July 3, 2024

RE: Responses to Site Development Comments
Dutch Bros Coffee (CO0907)
5810 Omaha Boulevard, Colorado Springs, Colorado
City File No. PPR2413 / Our Job No. 23098

Cherokee Metro

2

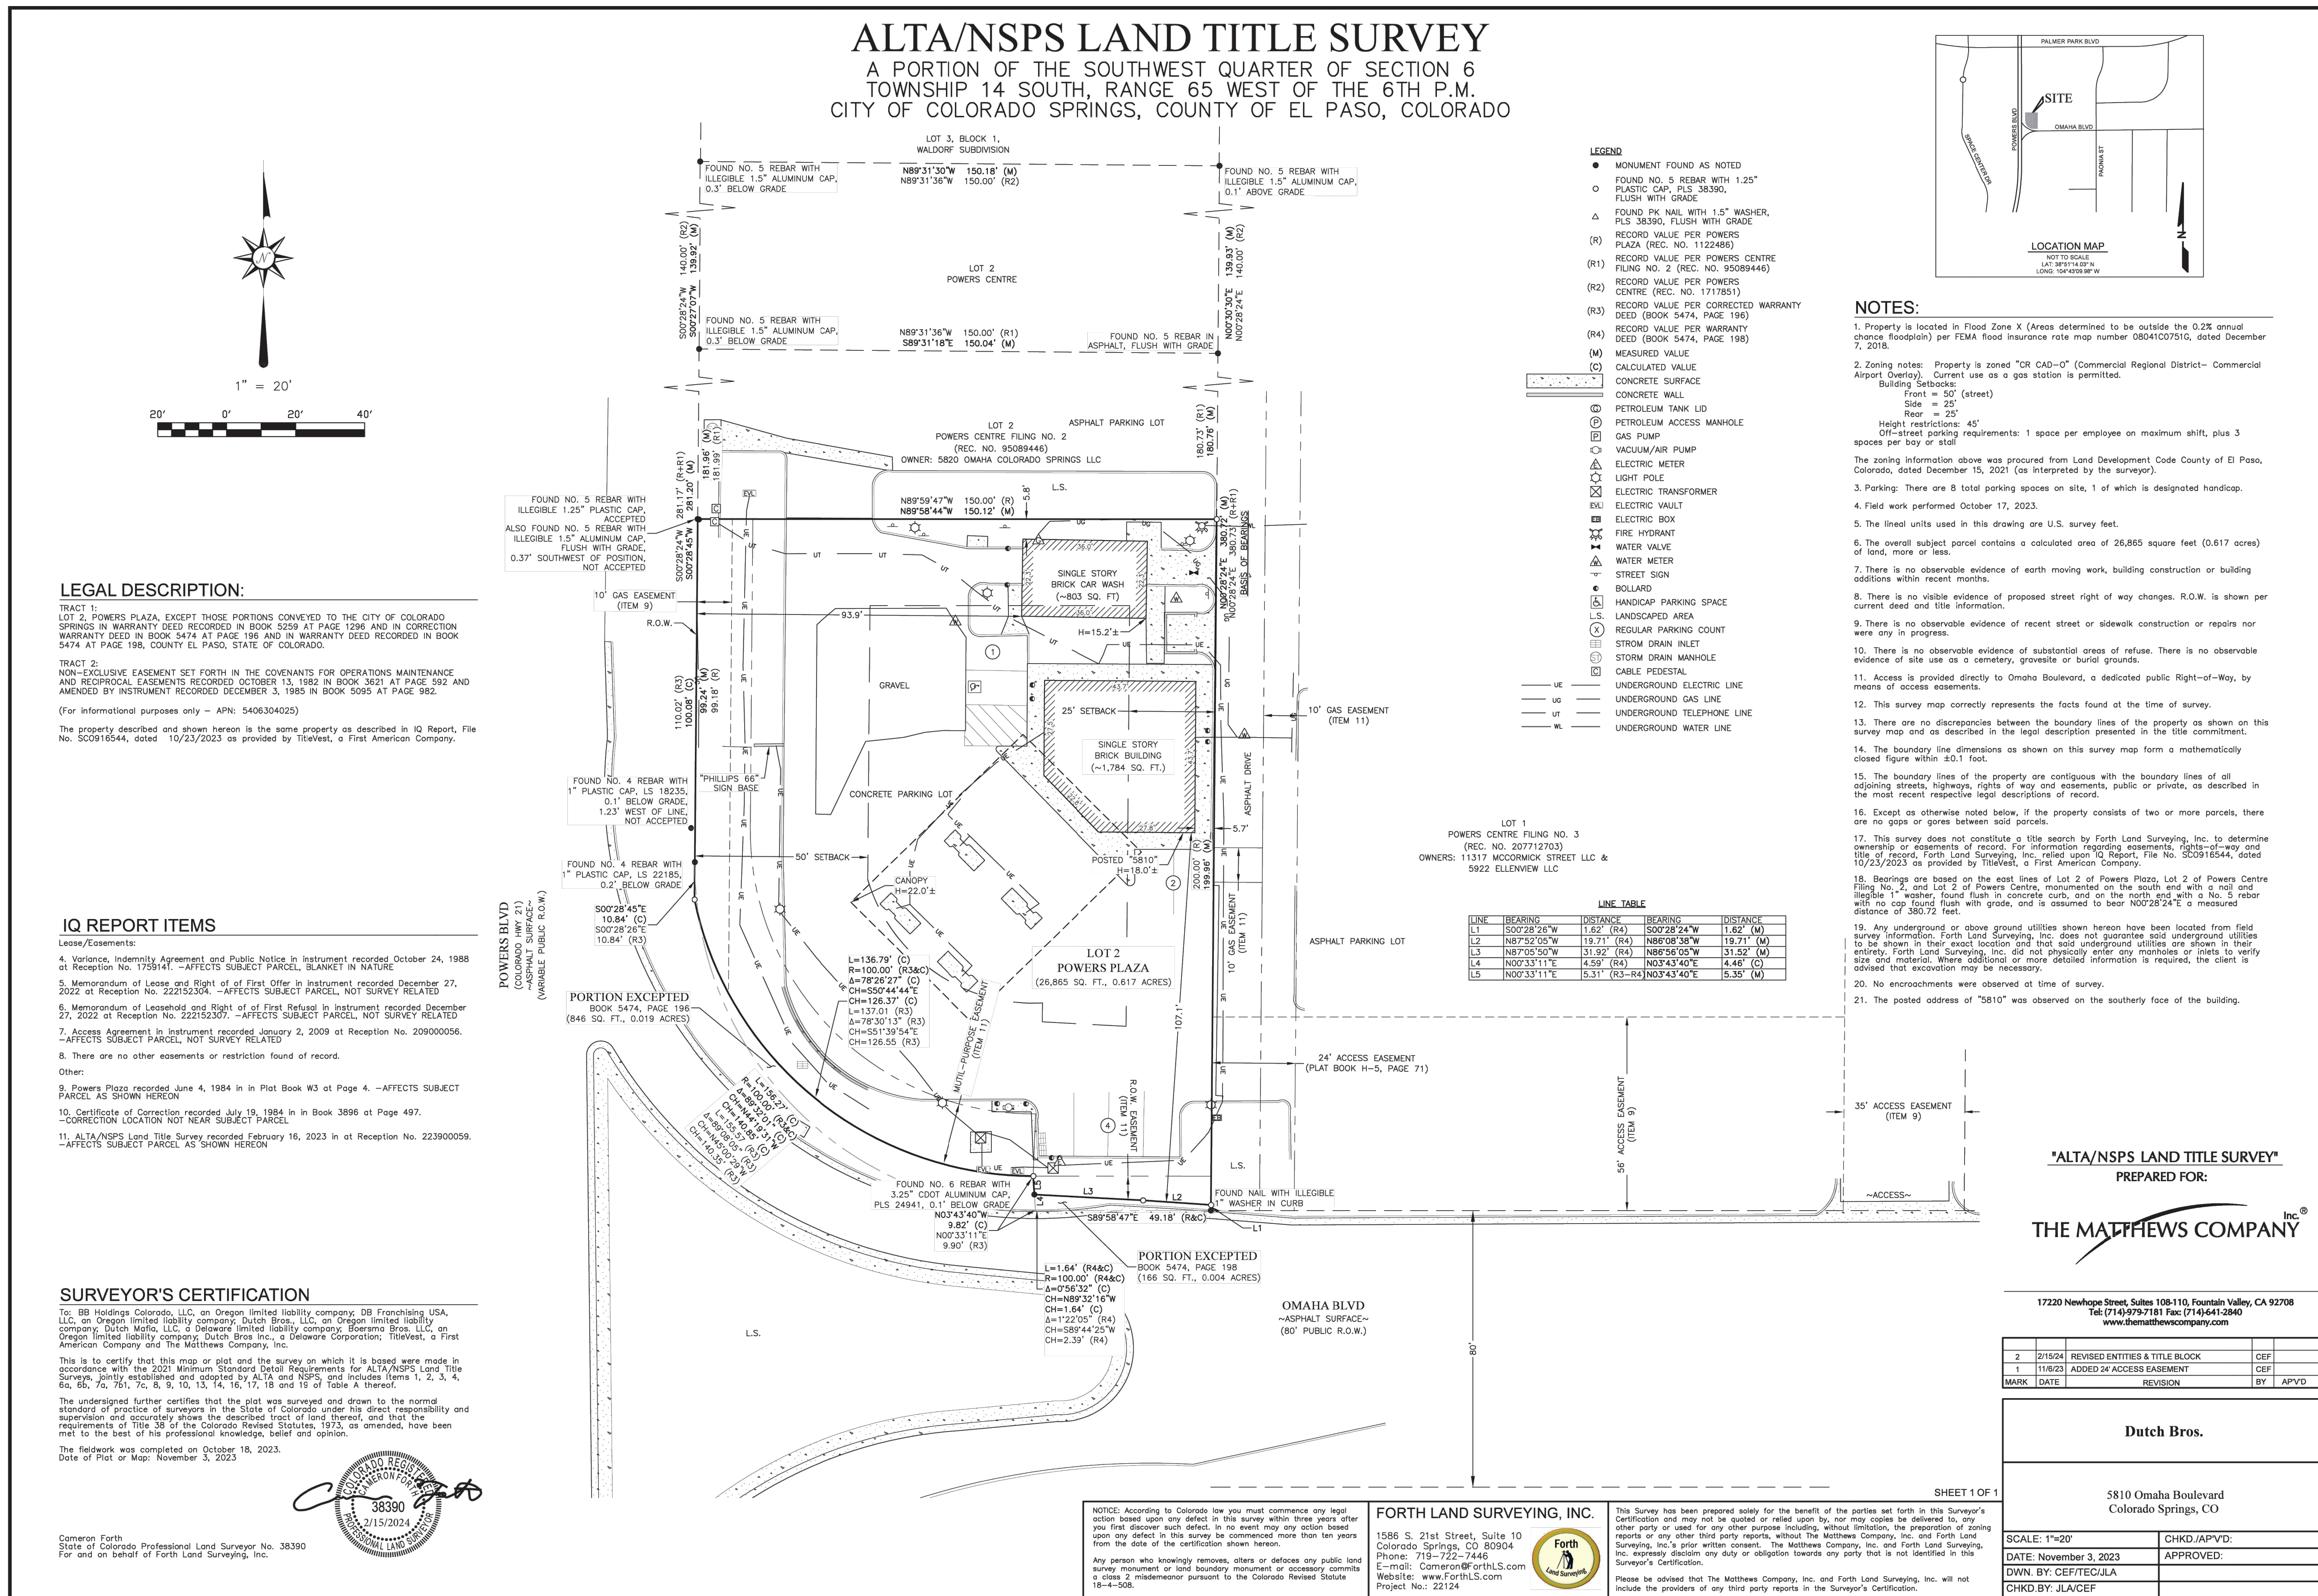
1. *Notes for Sheet 2 "General notes" need to explicitly state that CSU 2023 standards with Cherokee additions (can be found on cherokeemetro.org)*

Response: This comment is noted. A note has been added to Sheet 2 under the Cherokee Metro District Notes.

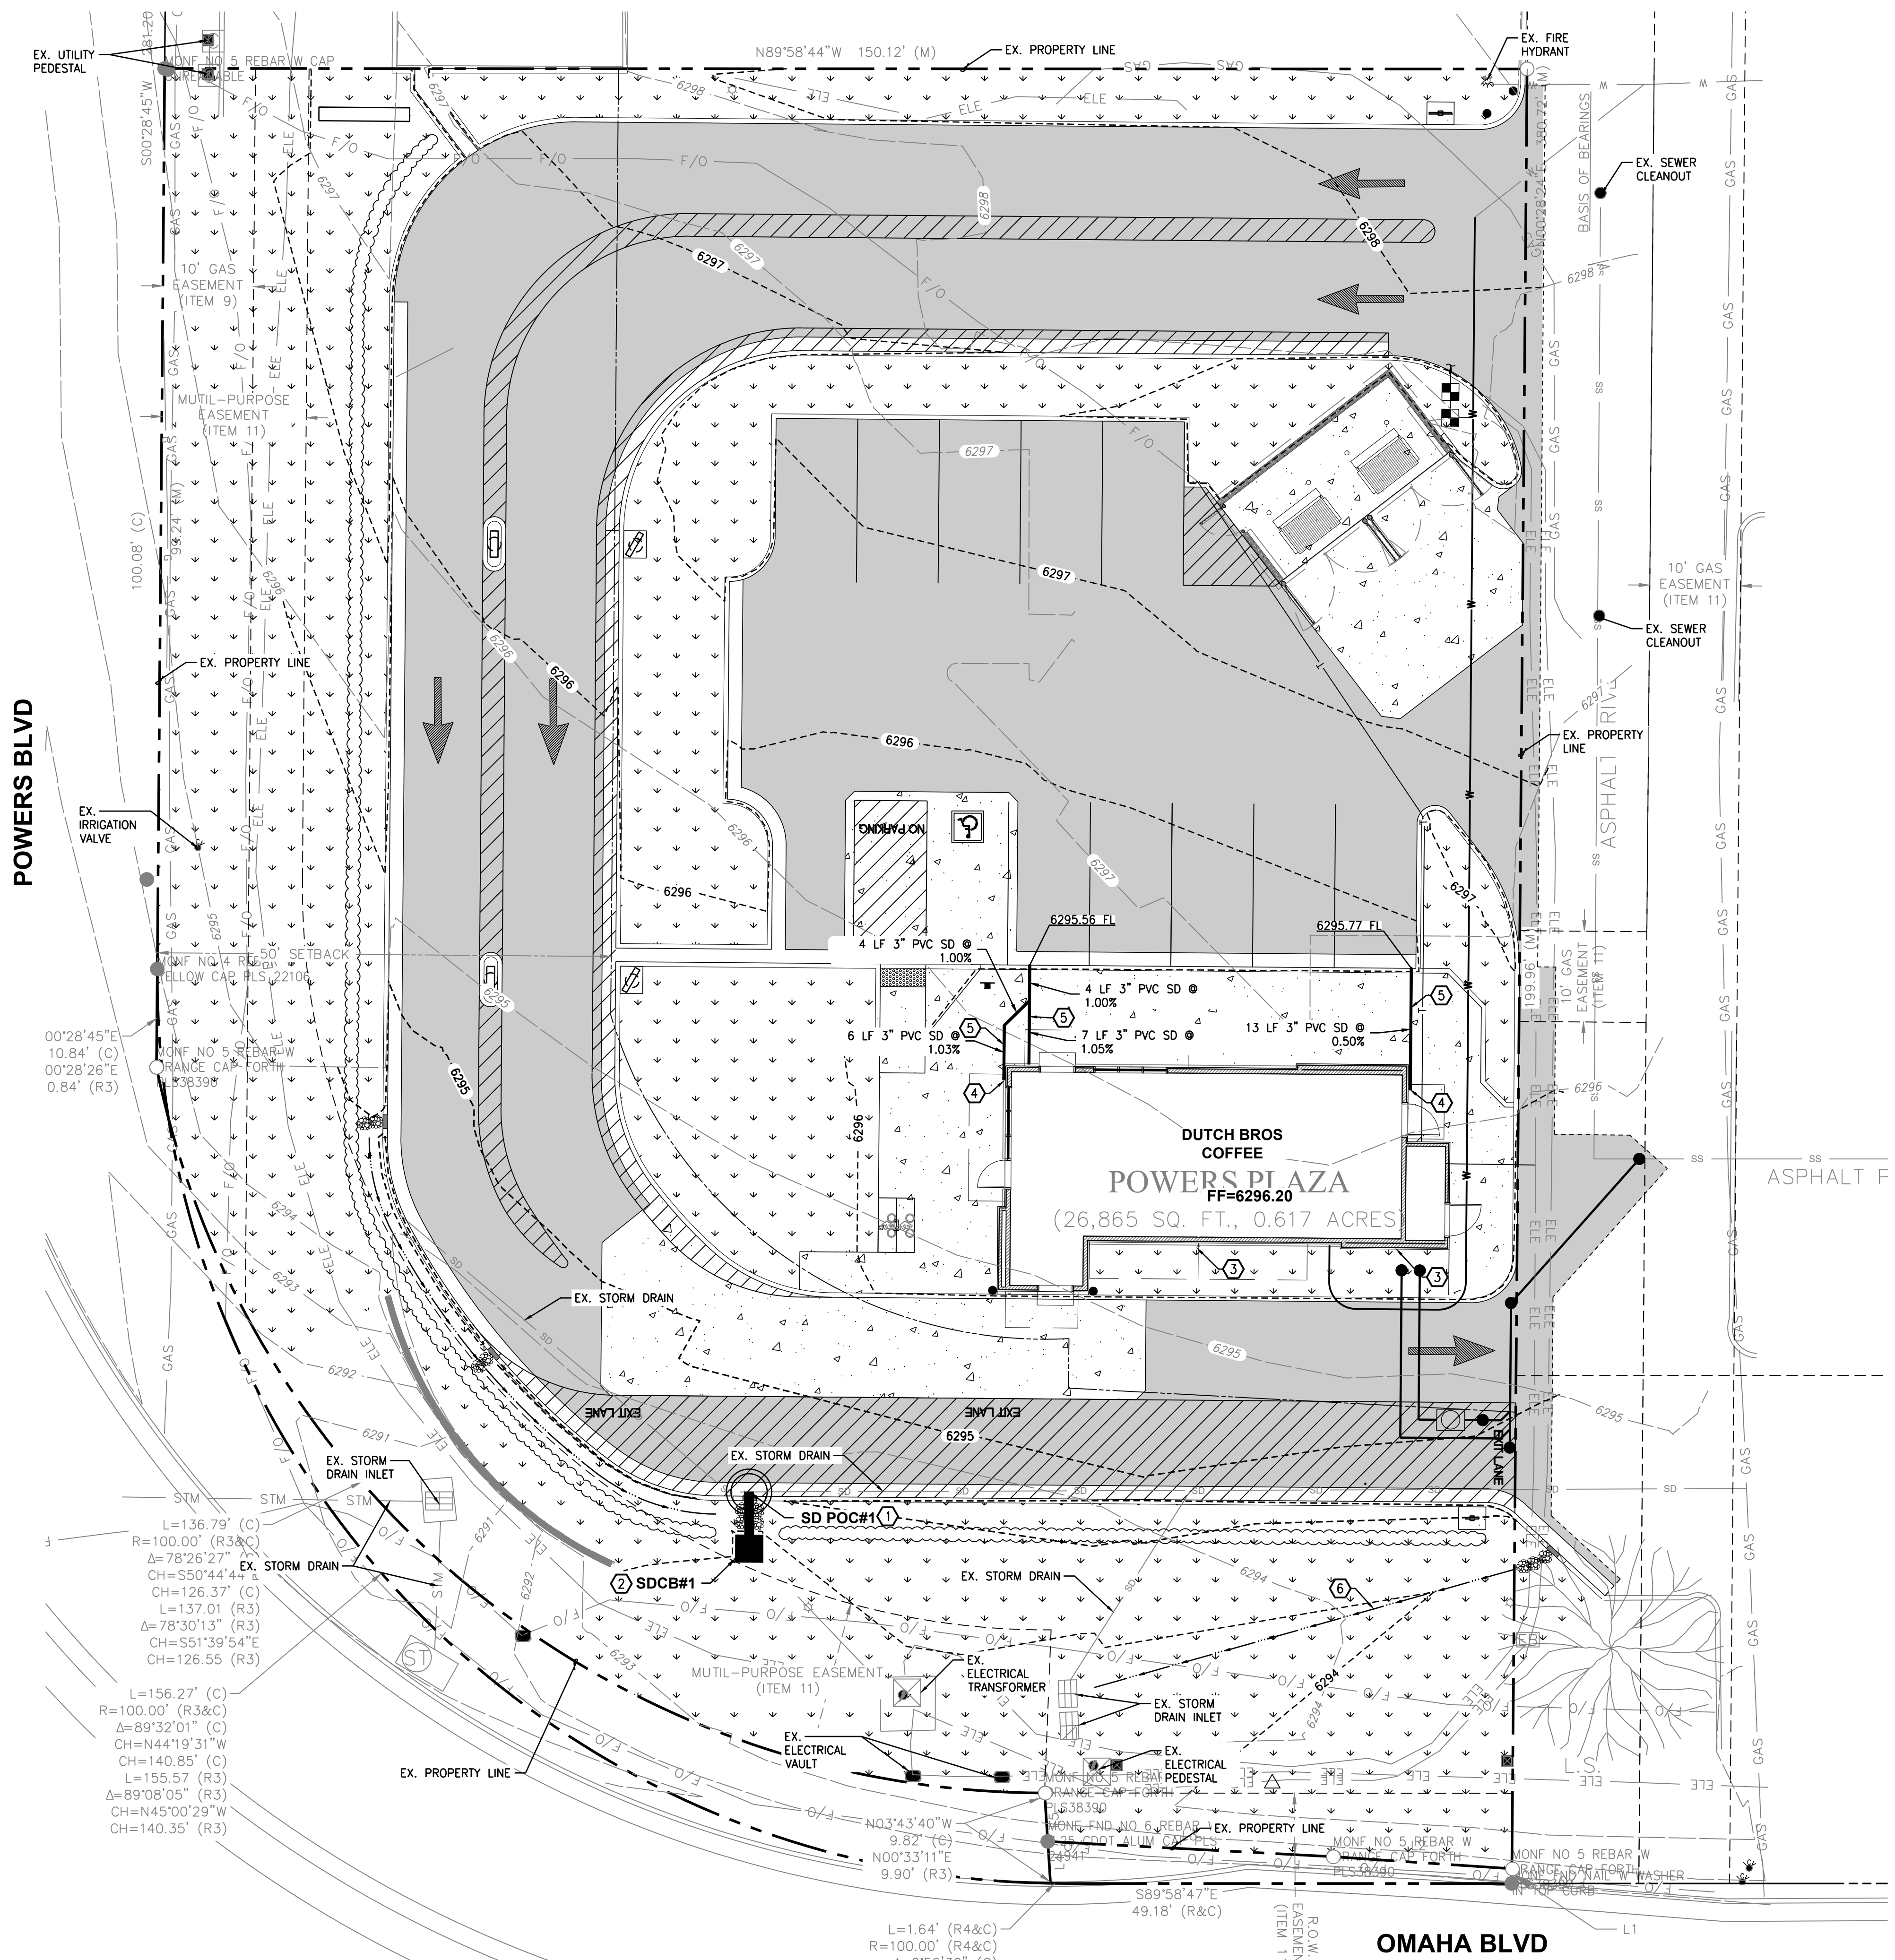
3. *on page 10, symbology for existing water line is inconsistent with legend.*

4. *on page 10 water and sewer entrance and exit are within 10 ft in a parallel formation. Secondary containment needs to be specified on the sewer line.*

7. *Proposed W looks like it is 5' from other Gas/E uts*

8. *Water and sewer mostly in compliance except where water enters and sewer exits*

Response: The symbology has been updated.

Response: This comment is noted. Sewer and water that exits out of the building has been revised.

Response: This comment is noted.

Response: This comment is noted. Sewer and water exiting out of the building has been revised.
